PLANNING CONSULTATION RESPONSE

Application No	2026/0165
Proposal	Erection of agricultural building
Address	Land to the east of Cat Hill Lane, Hoylandswaine, Sheffield
Date of Consultation Reply	18/08/2026
Consultee	Katie Lawrence, Planning Ecologist

Thank you for providing the updated Biodiversity Net Gain (BNG) Assessment and associated biodiversity metric in support of the above application. My comments are as follows:

Figure 1
Baseline Habitats Map

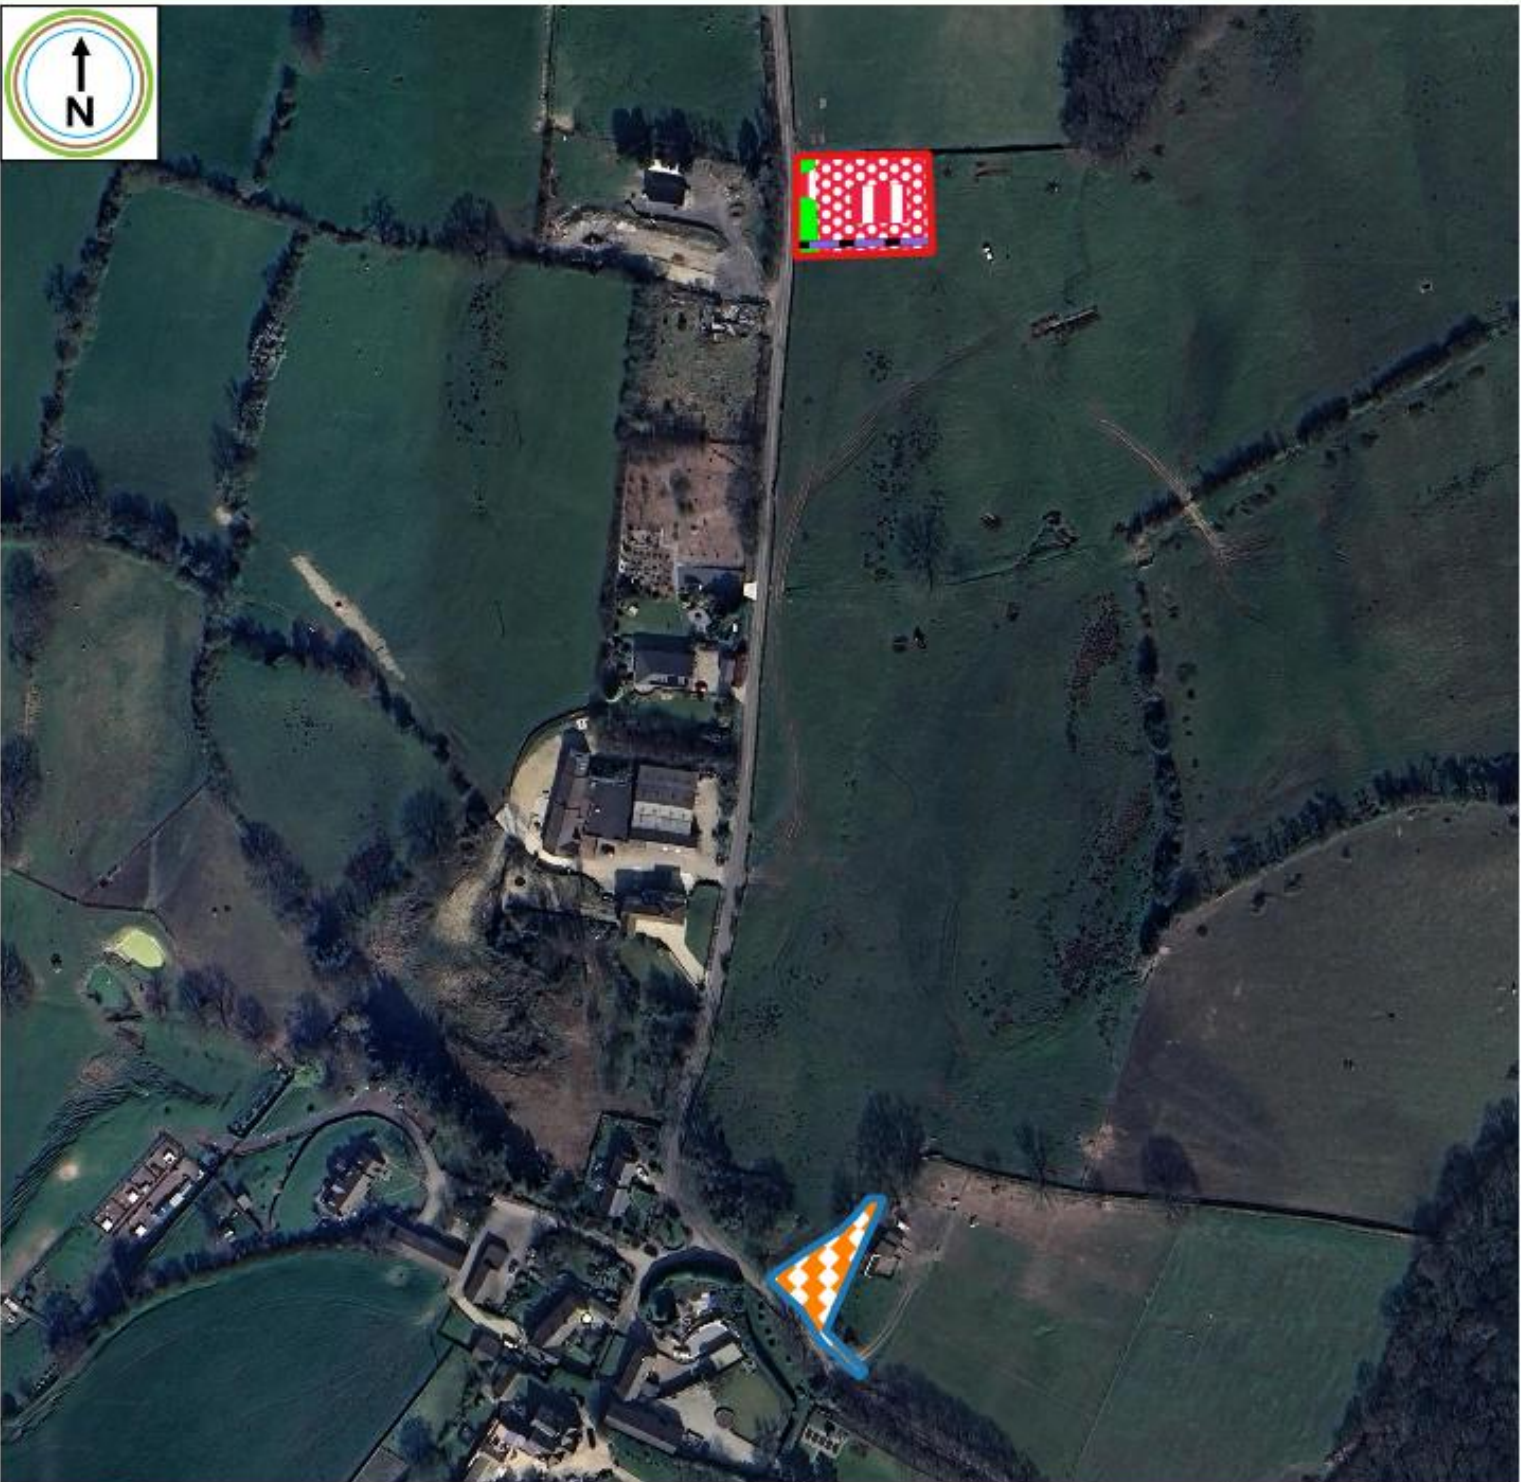
- Table 2 and Table 3 of the BNG Assessment report set out the baseline value of the areas where development and habitat enhancement are proposed. The area of the development site is 0.13ha in size and the habitat enhancement area is 0.06ha in size. The total area of baseline habitats within the metric is 0.13ha, so it doesn't appear to account for the habitat enhancement area. This should be checked and amendments made, where necessary.
